Client: Persimmon Homes Thames Valley
Project Title: 19163- Sites A2 & B6 Littlehampton, West Sussex
Rev: - 1st Issue
Date – 14th May 2020

**Drainage Consultee Response for Residential Development at Hampton Park,
Parcels A2 & B6, Toddington Road, Littlehampton. Ref LU/90/20/doc**

© This drawing and the building works depicted are the copyright of Banners Gate Ltd and may not be reproduced or amended except by written permission. No liability will be accepted for amendments made by other persons.

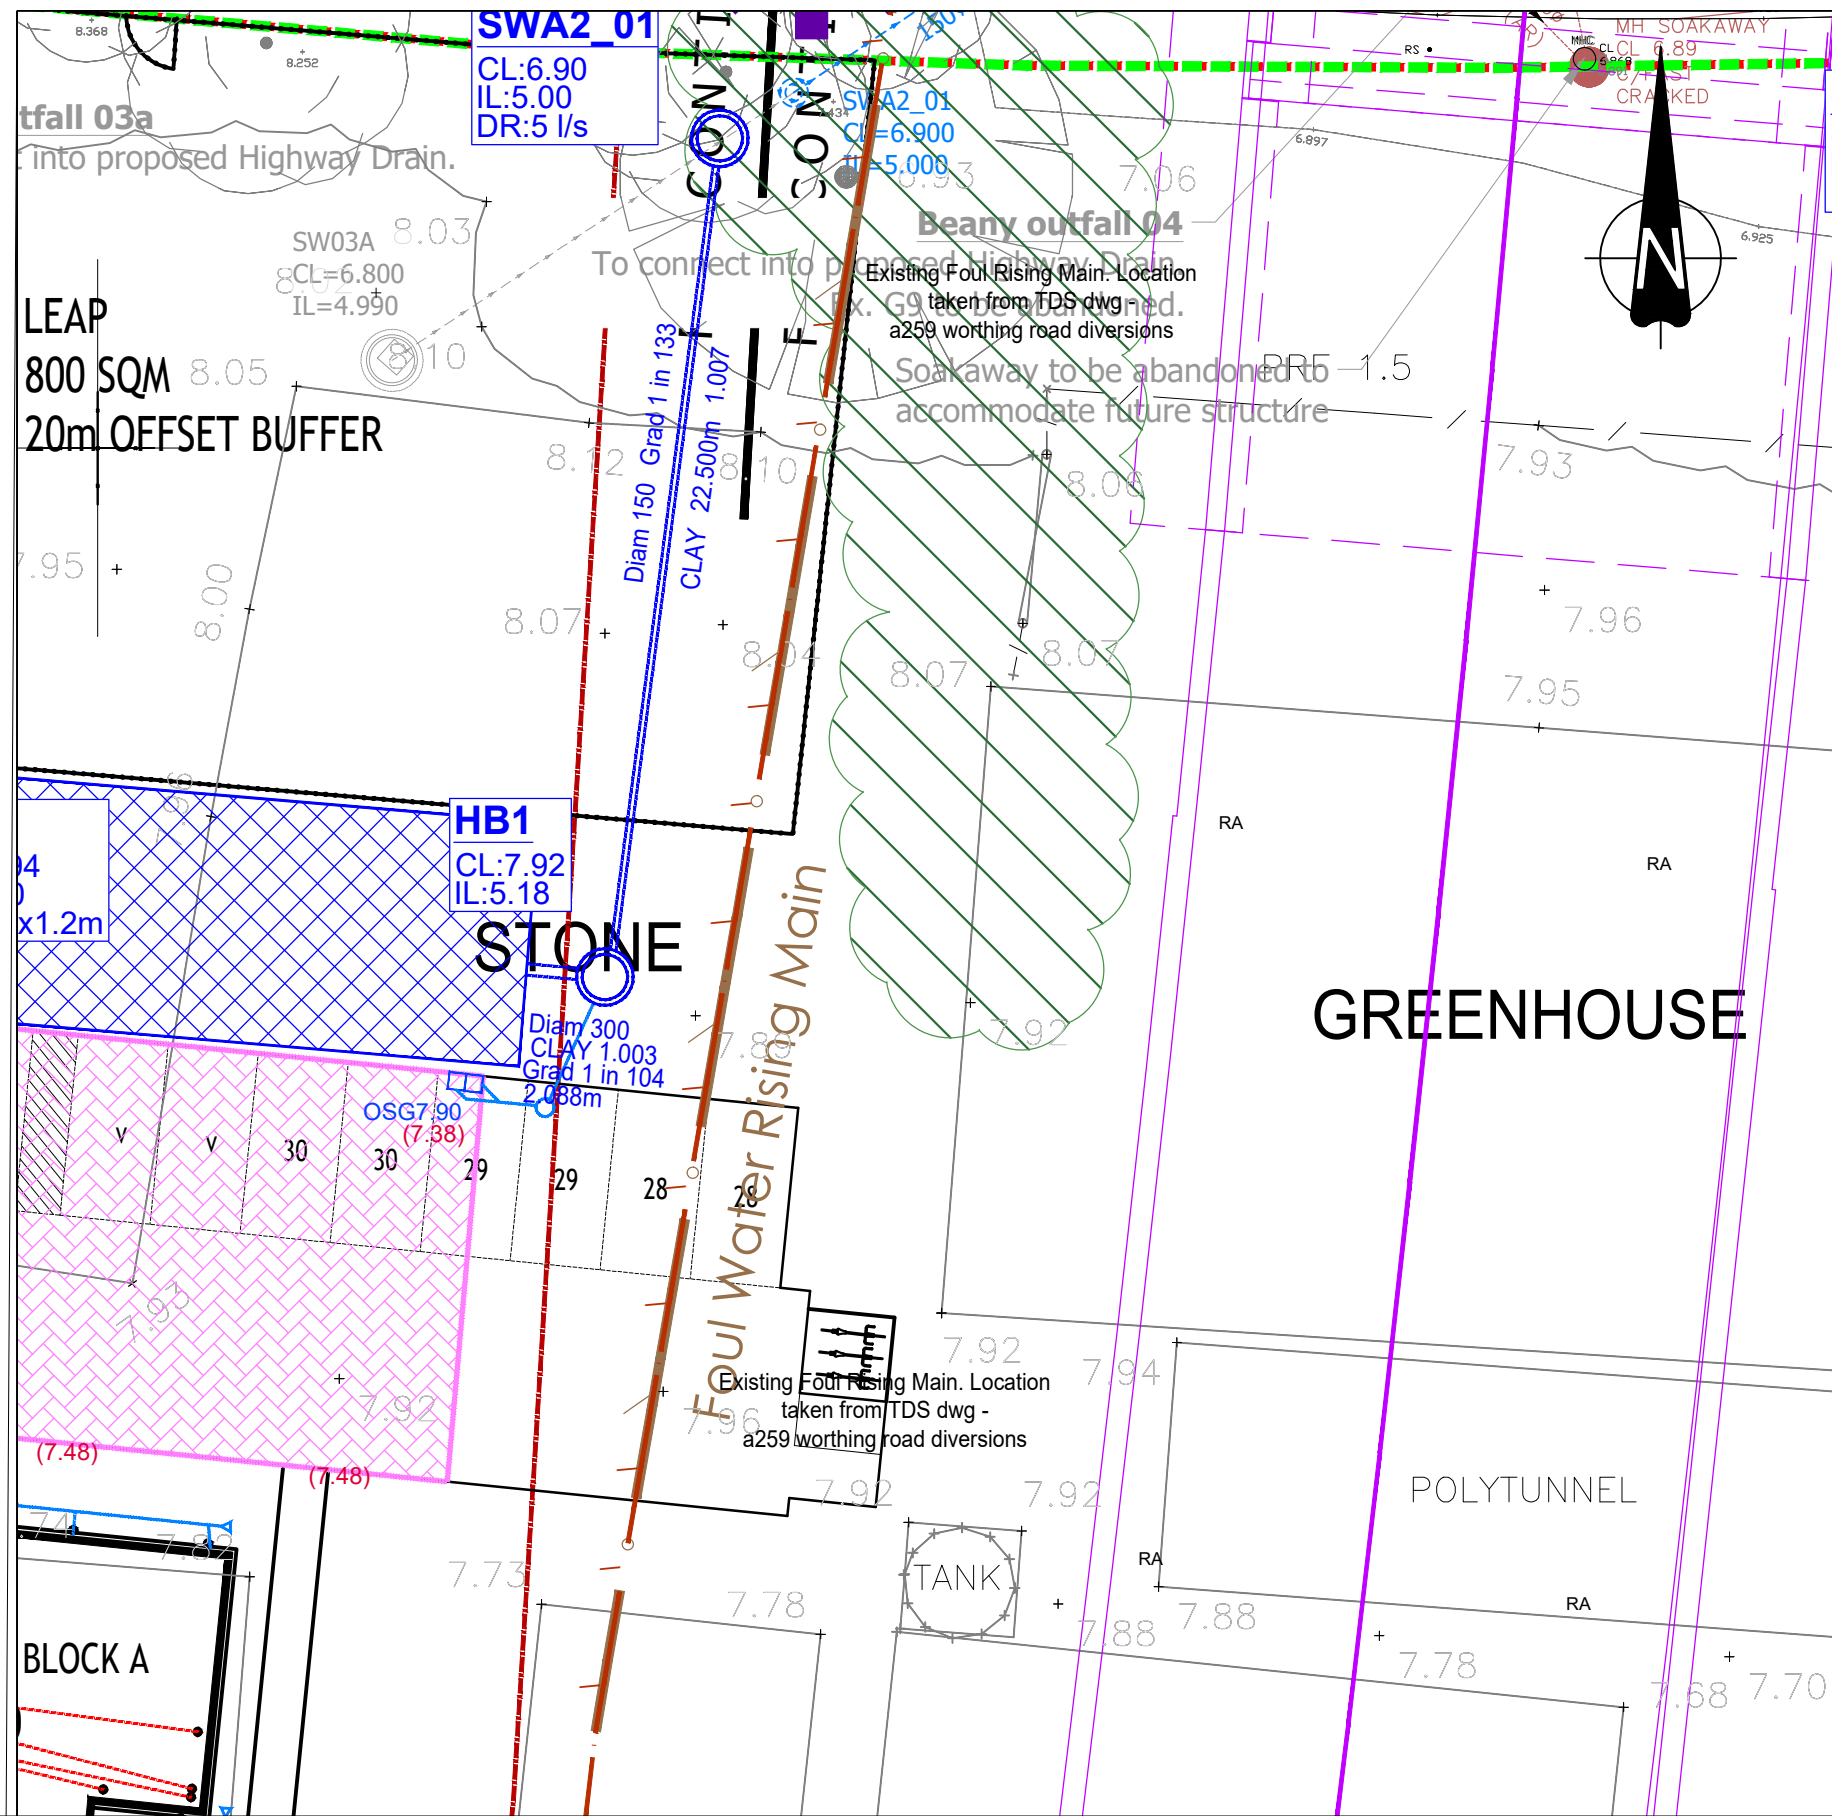
4. *Indicate allowable discharge rates on the plans and provide hydrobrake technical data sheets from the manufacturer. Allowable discharge rates indicated on drawing no 19163/100S104 at control chambers. Hydrobrake tech data sheets and Construction details are contained within Appendix D.*

Hydro-Brake Control Chamber HB2

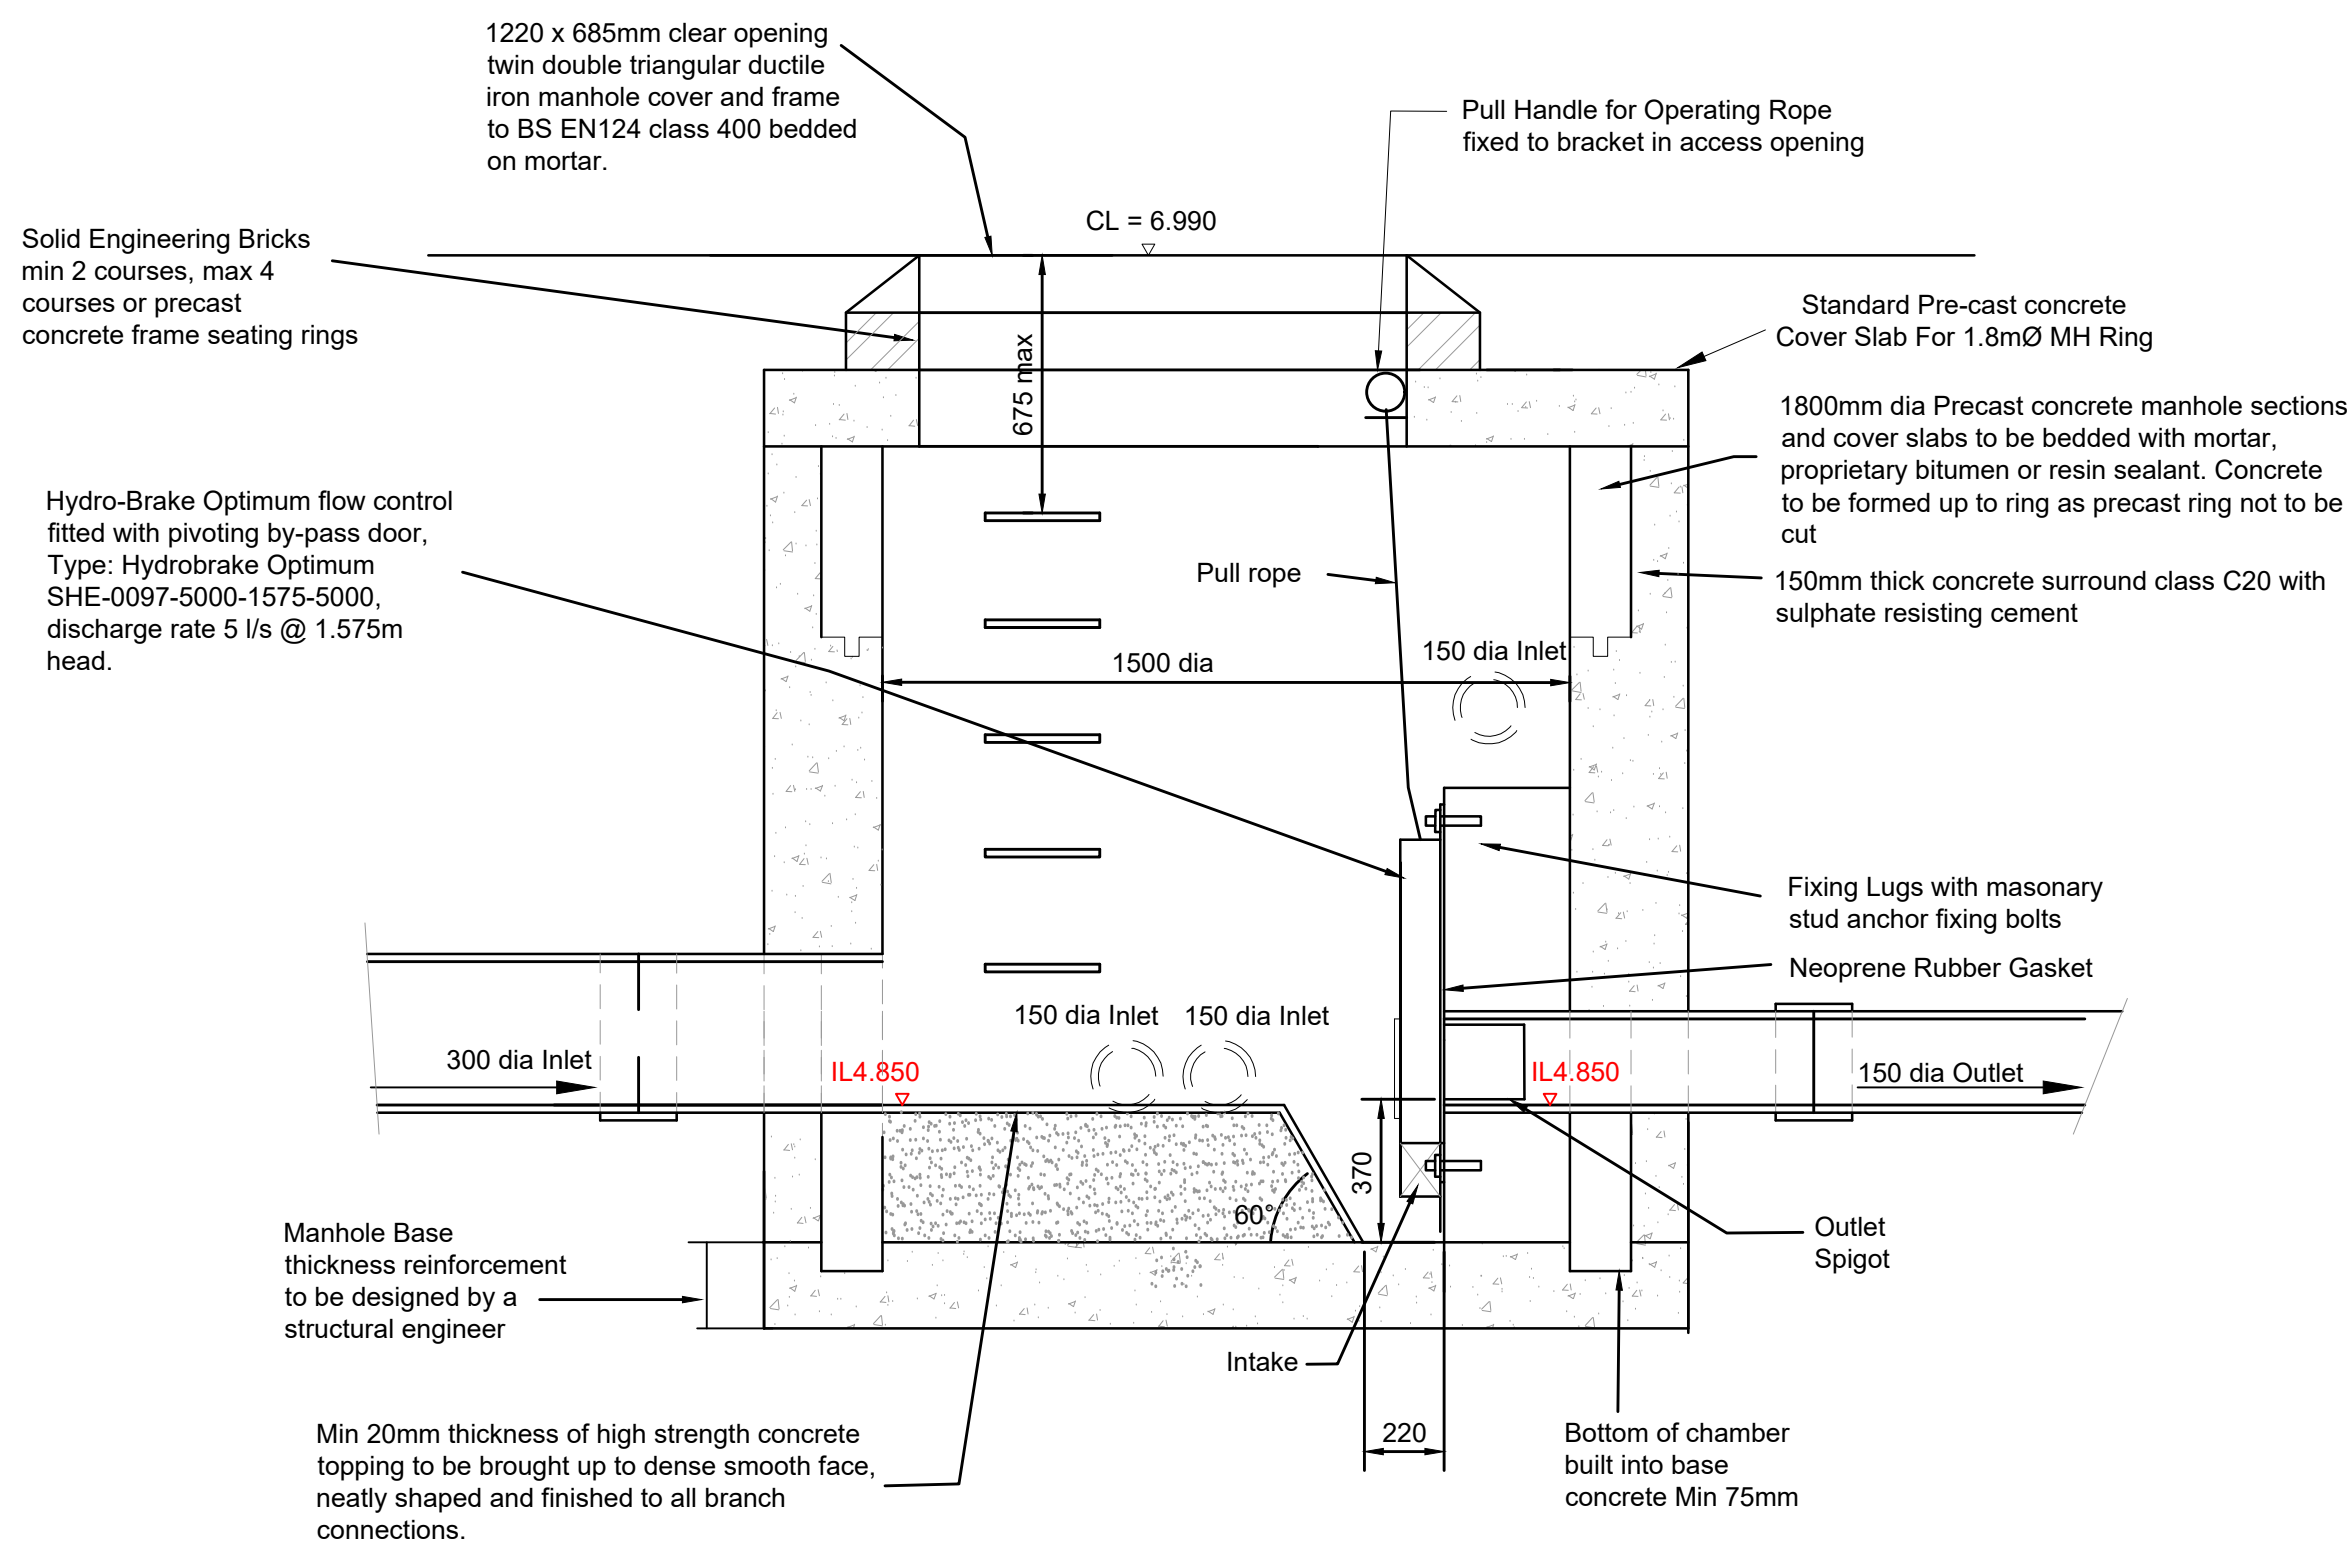
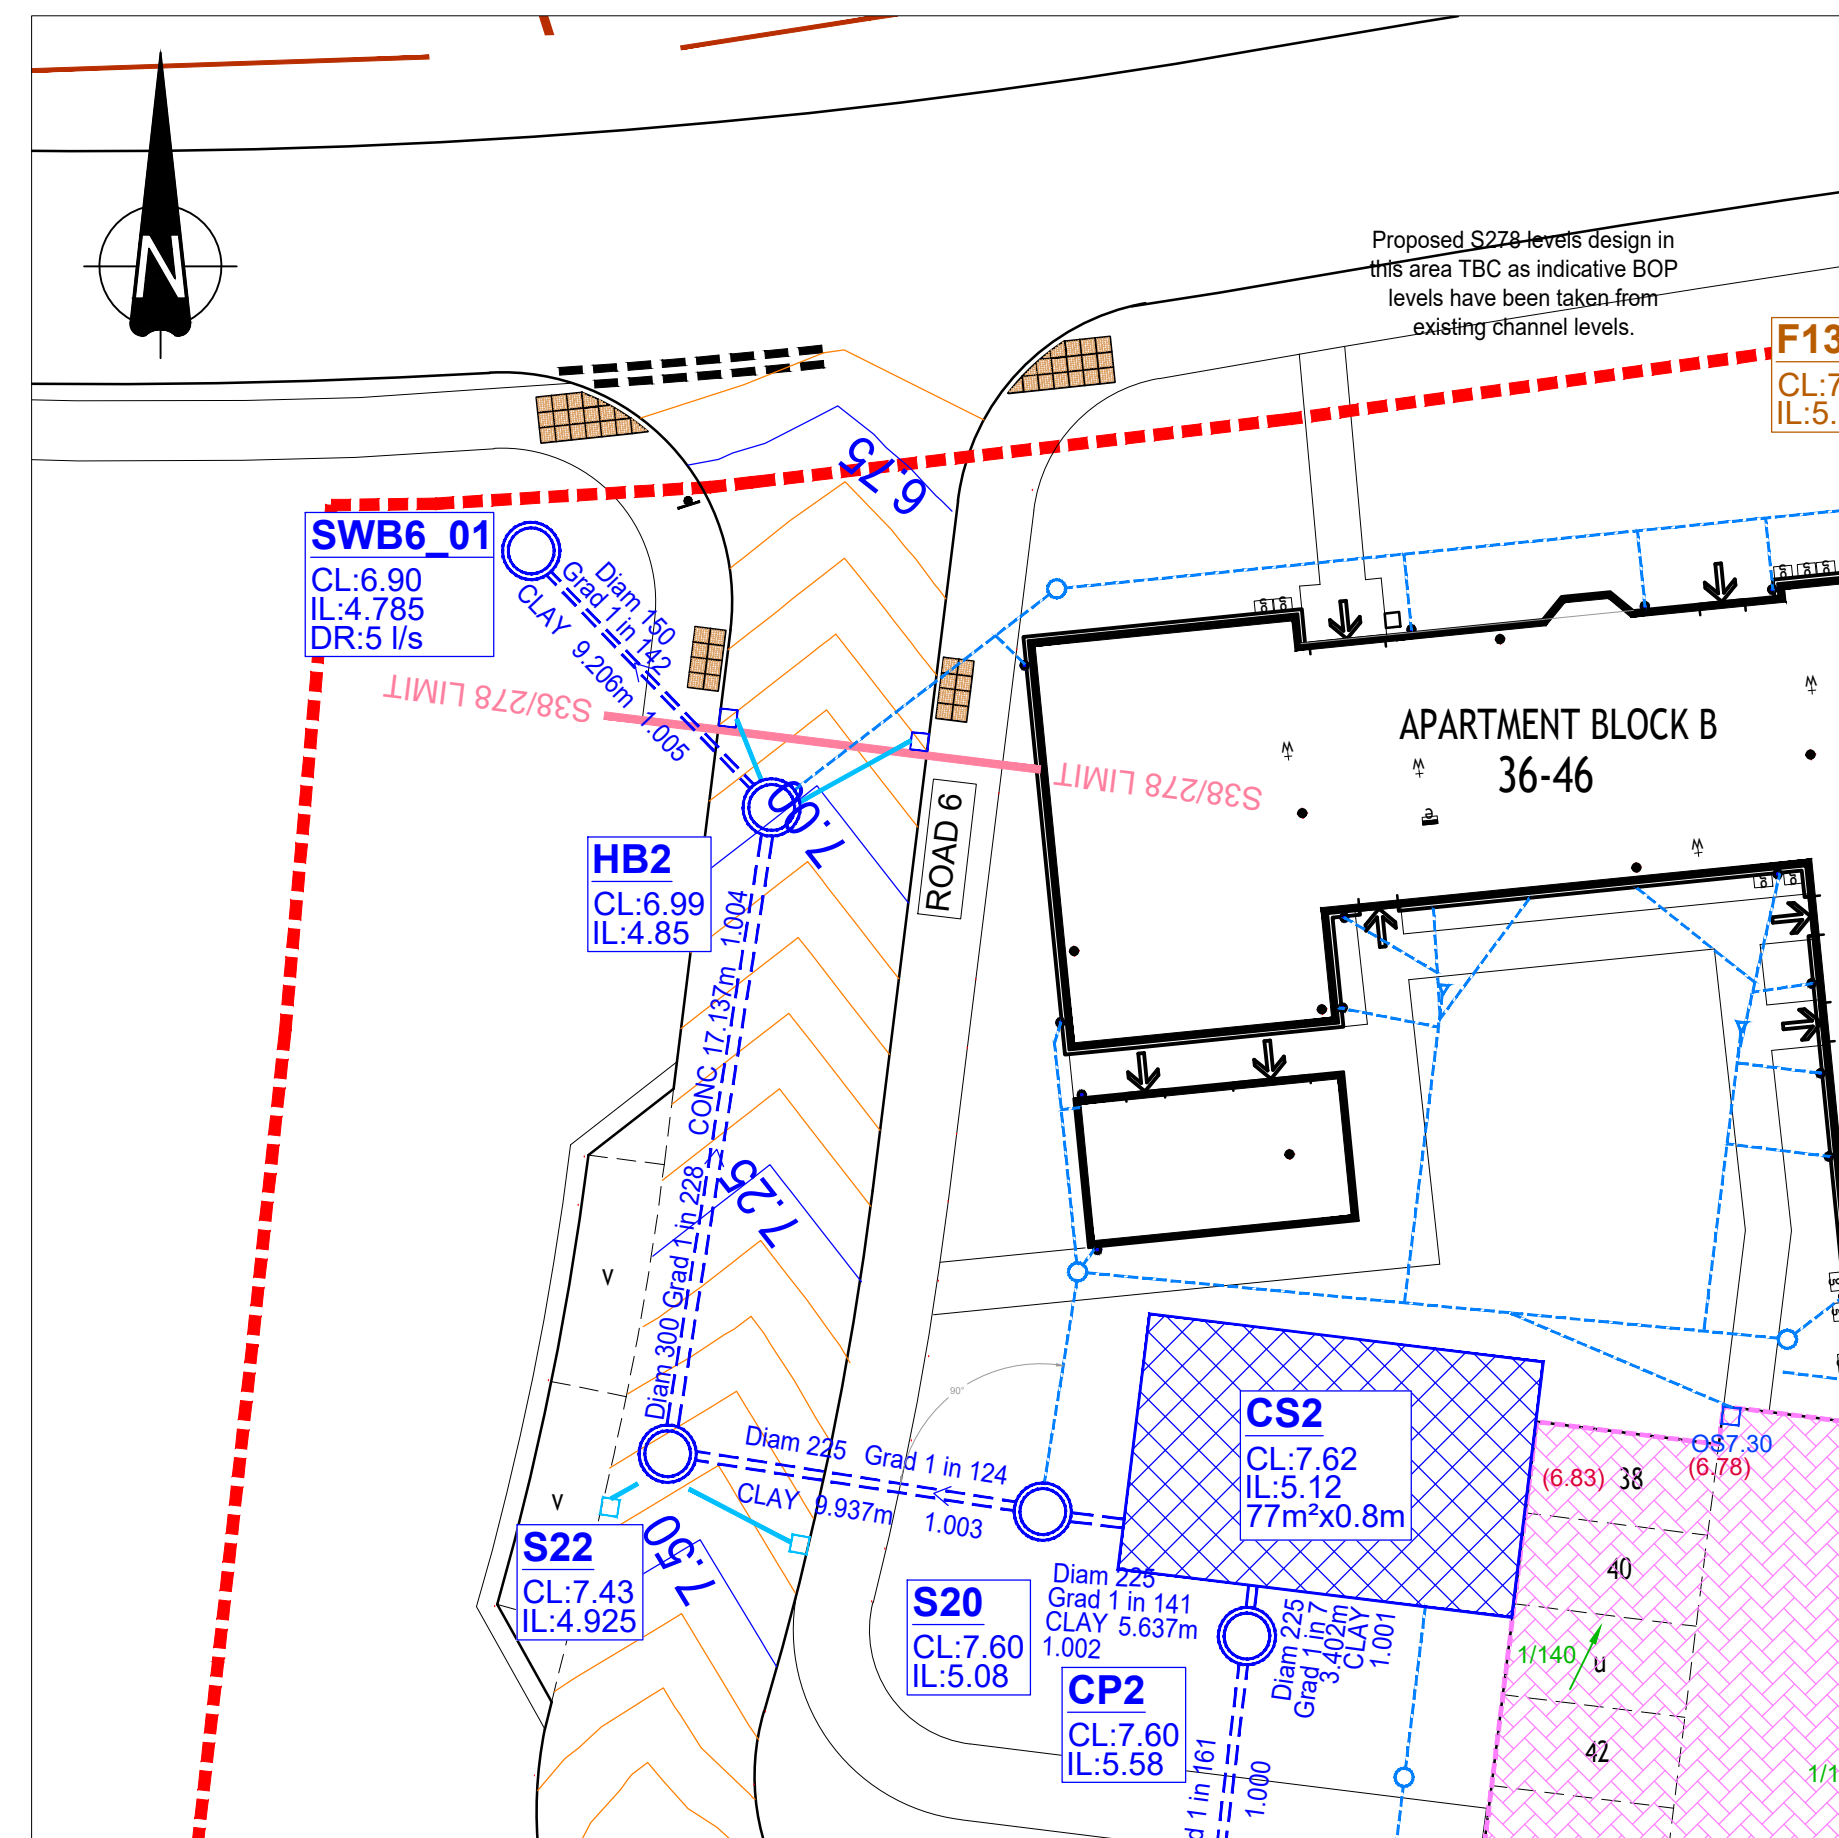
14. *Can the CS2 tank be online rather than offline? Tank now on-line as requested.*
15. *Gully north of HB2 control chamber is connecting against the flow. Reconfigure the arrangements here to improve the situation. Appreciate comment but the road gully connection is discharging to the sump of the hydrobrake. We have endeavoured to try and produce a practical design and taking into consideration the outfall location and the orientation of the various connections believe it is a more practical arrangement. It would be appreciated if the arrangement could be accepted in this instance.*
